05 June 2017.

Re: R/91/17/PL Erection of 2 dwellings & garages – The Spires

PLOT 2 PROPOSED
GROUND FLOOR
PLAN
SCALE 1:100

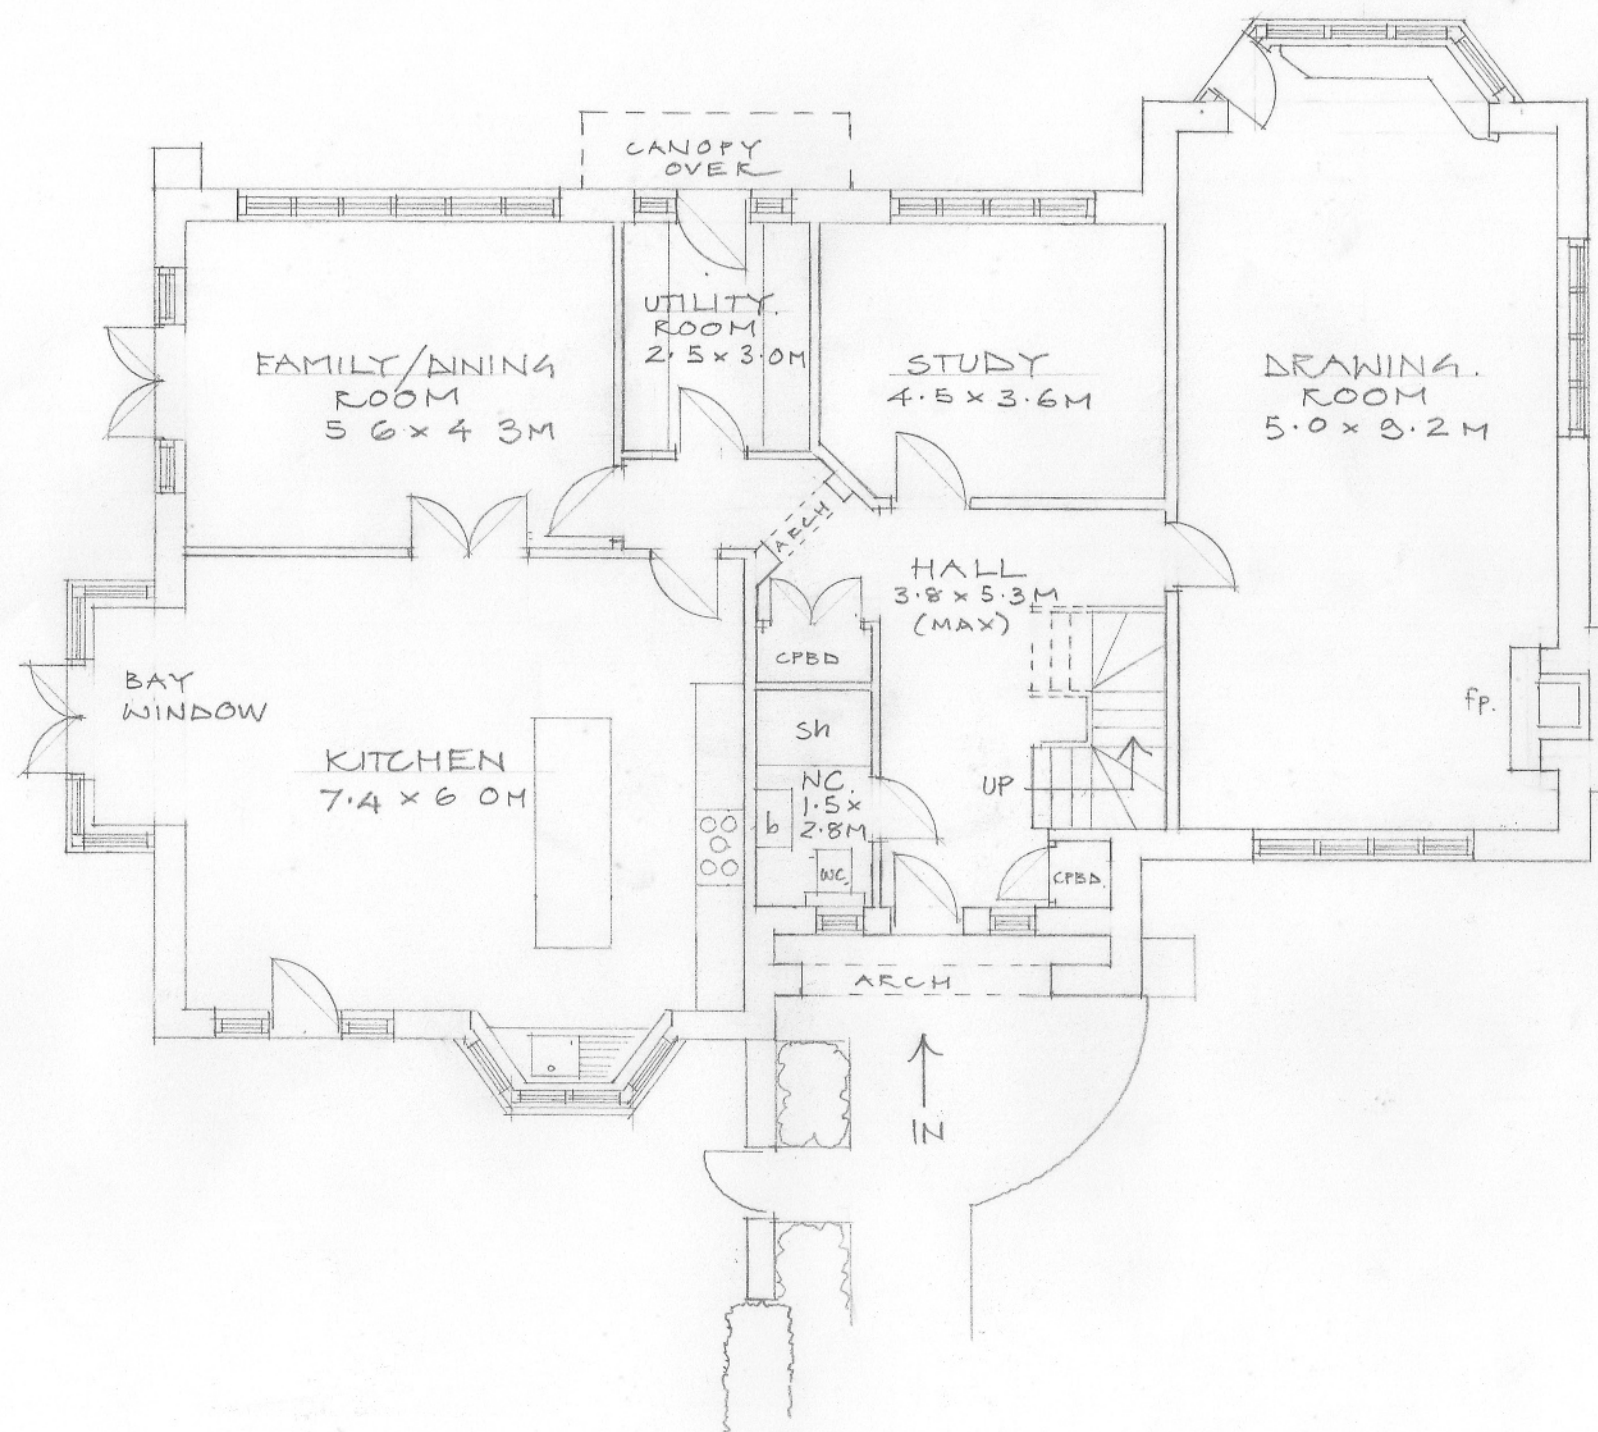
We write in respect of the proposed Plot 2, which is a mere 12 metres from our southerly boundary. That is, 12 large footsteps. This we believe is unreasonably close given that the distance from The Spires to the proposed dwelling on its southern elevation is 19 metres, more than half as much again.

We consider a better positioning would be 15 metres from our boundary and 16 meters on the southerly elevation to The Spires. At the same time we feel the proposed dwelling should be positioned further to the east as far as the black poplar tree roots permit, say 5-10 meters.
